**CITY OF ALBUQUERQUE  
PLANNING DEPARTMENT  
August 13, 2008  
DRB Comments**

**PROJECT # 1007297**

**RE: Block D, Indian Acres**

**RE: Block D, Indian Acres Subdivision**

**STREET IMPROVEMENTS FOR
A PORTION OF BLOCK D
INDIAN ACRES SUBDIVISION
CITY OF ALBUQUERQUE
BERNALILLO COUNTY, NEW MEXICO**

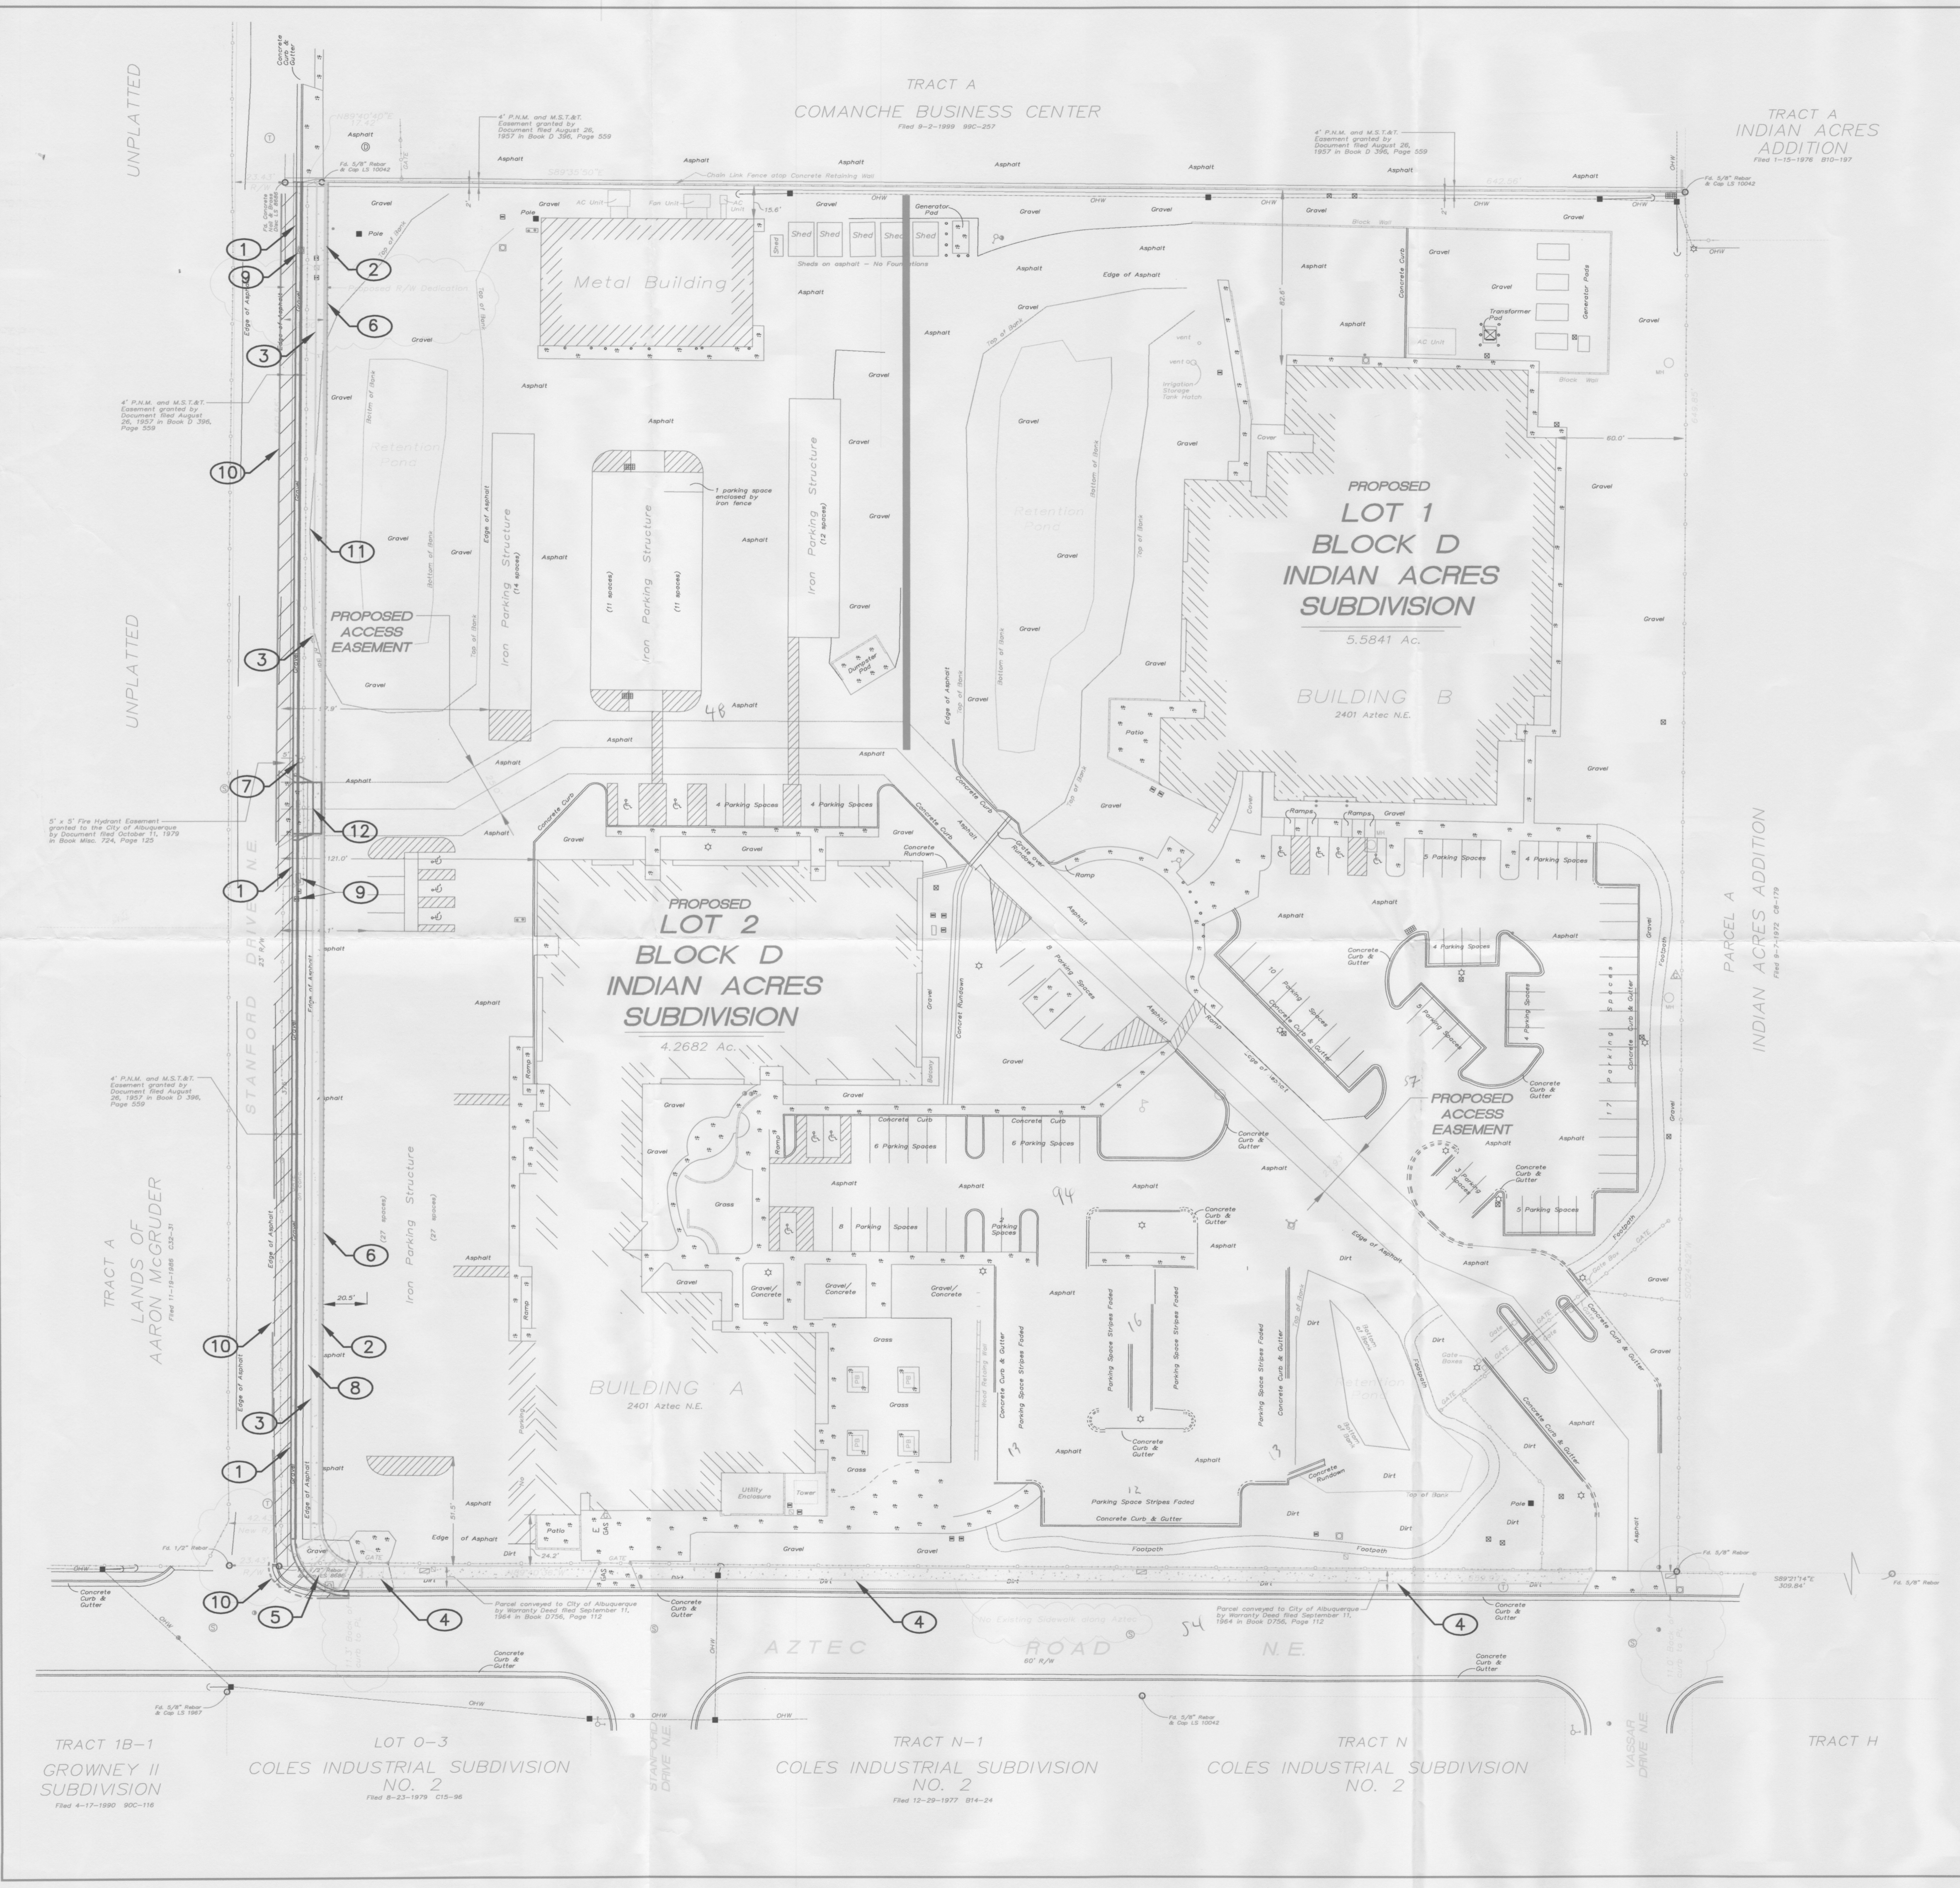
It appears additional right-of-way will need to be dedicated along Stanford, which would remove some parking. In any case, a site plan with parking calculations will be needed to demonstrate that each proposed lot can meet its own on-site parking requirements. The plat will need to have a Solar Access Note per Section 14-14-4-7 of the Subdivision Ordinance.

SKETCH PLAT OF
LOTS 1 AND 2, BLOCK D
INDIAN ACRES SUBDIVISION

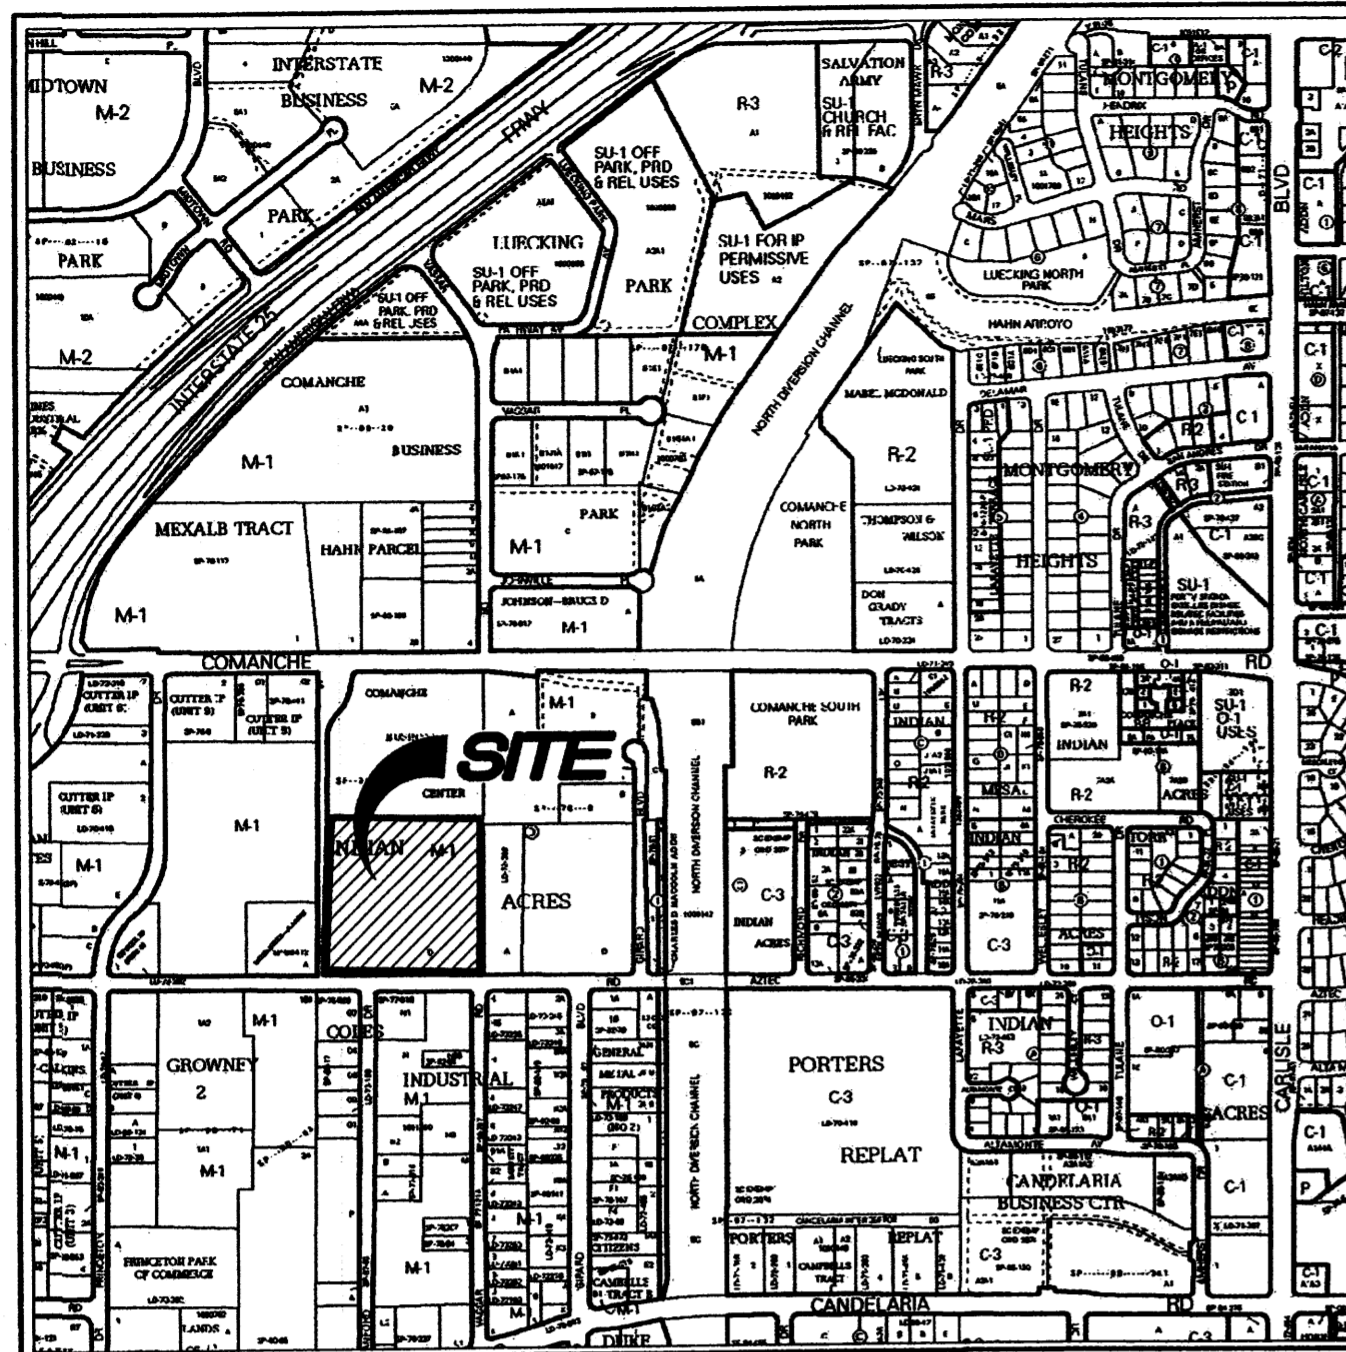
Need cross-lot drainage easement
